Our Case Number: ABP-318758-23

Re: Proposed public realm improvement works known as the "Westgate 2040 Project"
in Drogheda, County Louth

SUBMISSION RE: WEST GATE VISION 2040 – YOUR REF. ABP 318758-23

MADE BY: Brian Hanratty

DRAWING
Abbey Proposed Plans, Elevations Sections A-A and B-B

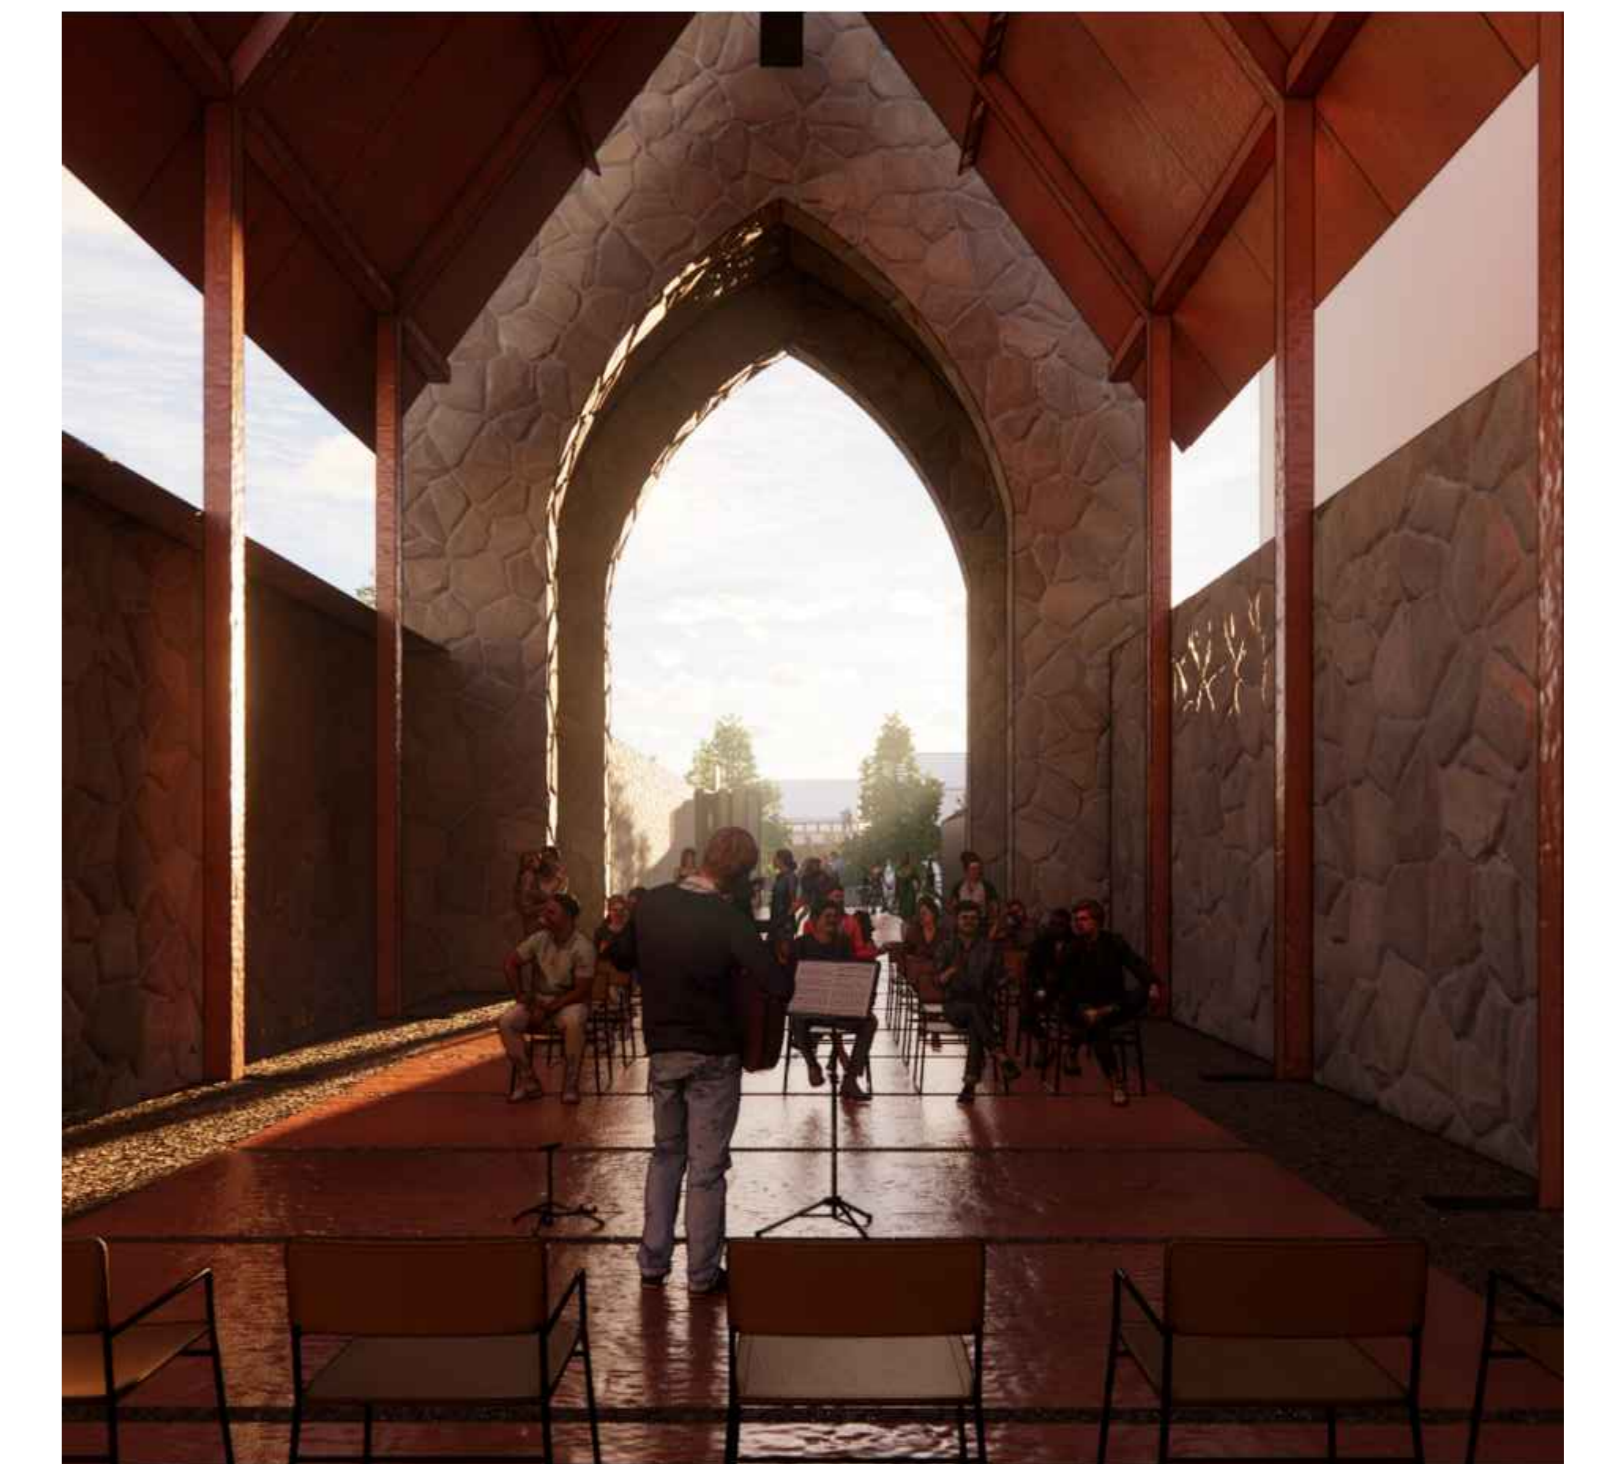
In relation to the proposed extensive use of Corten Steel, it is our view that it is an entirely inappropriate material and competes with the heritage assets such as the Old Abbey. A material and colour scheme that complements – rather than conflicts with such assets – should replace it. The two large uprights at the entrance are equally intrusive. Overall, it gives the impression of a “Corten Steel showroom” and is entirely inappropriate in our view.

I hope these suggestions will be considered. Our main concerns relate to the use of Corten steel. For example at the Old Abbey, proposed roofing could be in the colour of the Abbey’s stone to be less intrusive. Better signage and information regarding the WGV area; Drogheda generally and as its known as “The Gateway to the Boyne Valley,” panels which encourage visitors to explore further.

DRAWING
Detail Drawing 10
Corten Walkway - George's Square

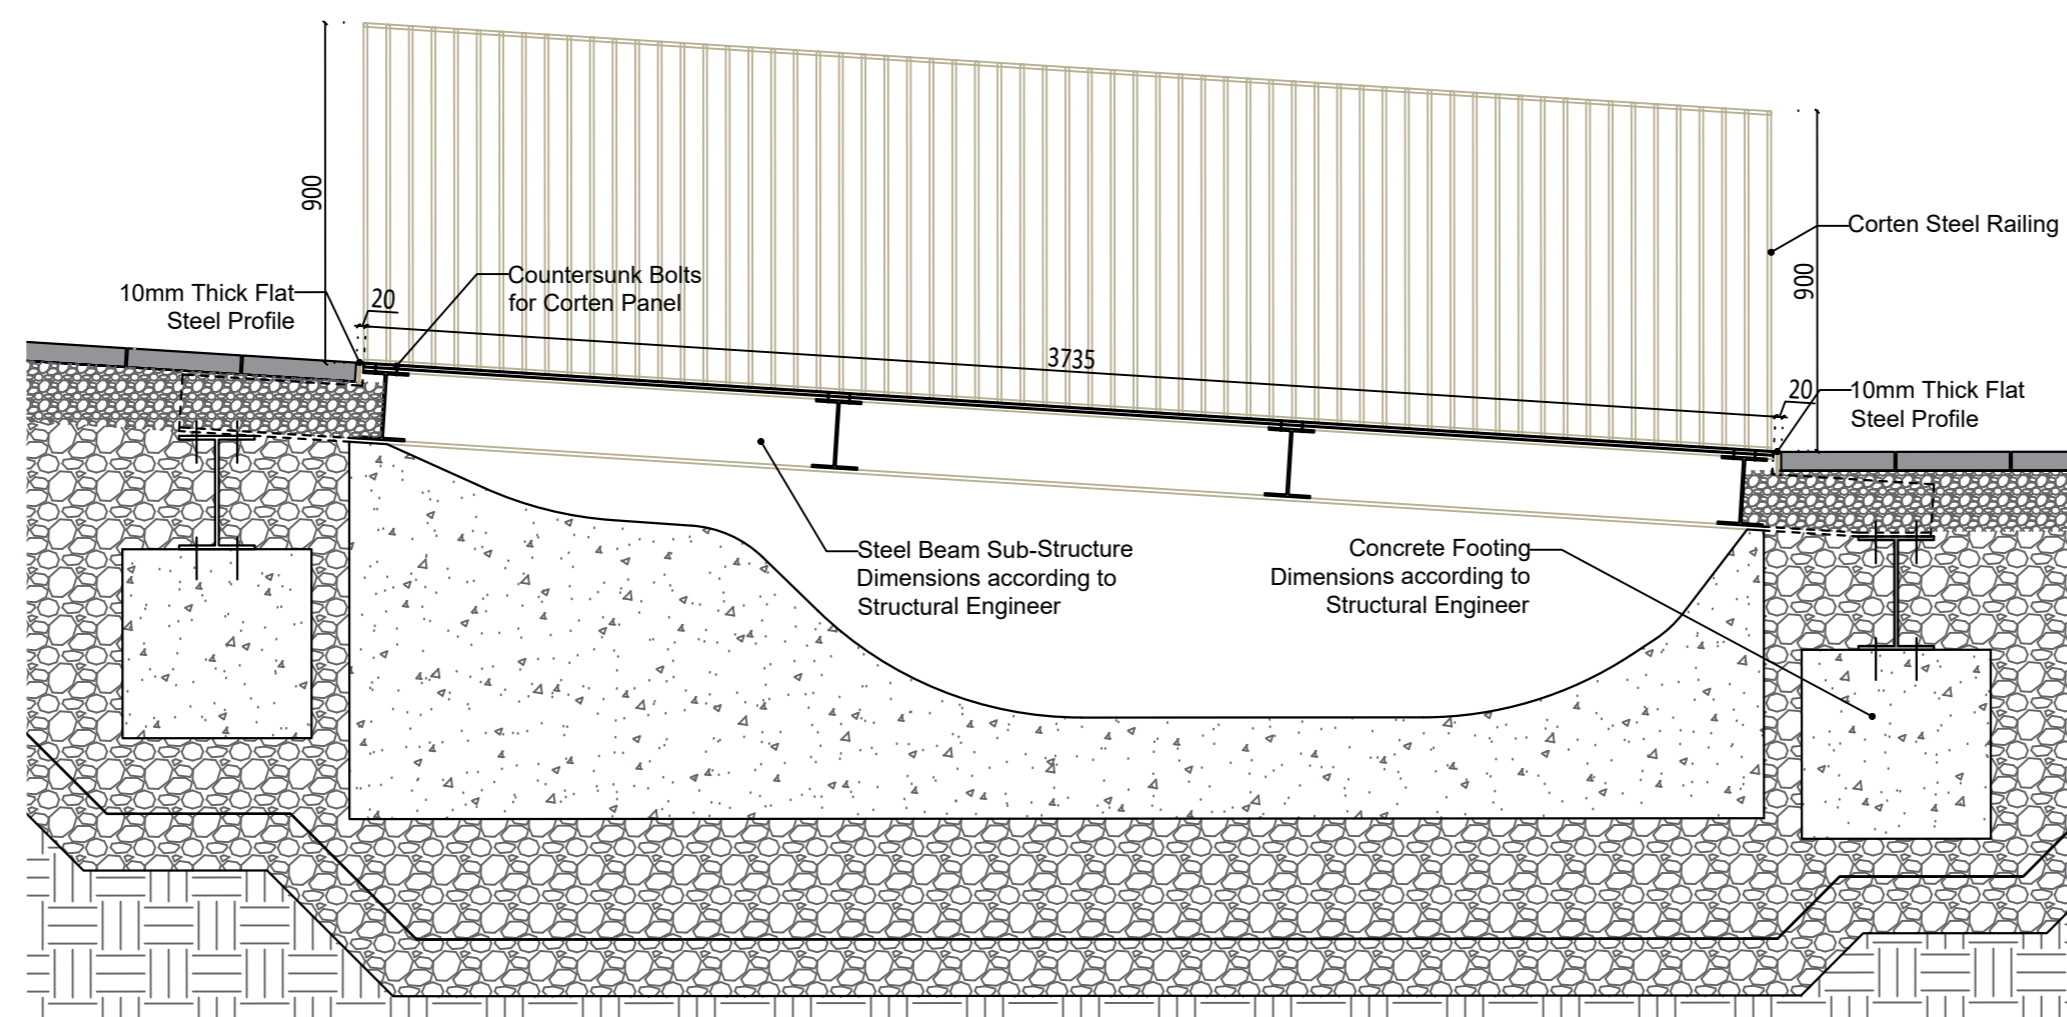
It is presumed – but not evident in a sketch of Georges Square – that wheel chair access is facilitated throughout the site. It is regretted that given Drogheda’s size and visitor potential, that the plan envisages the removal of the only public toilets which are adjacent to Drogheda’s busiest bus stops on Georges Square –which need a suitable bus shelter.
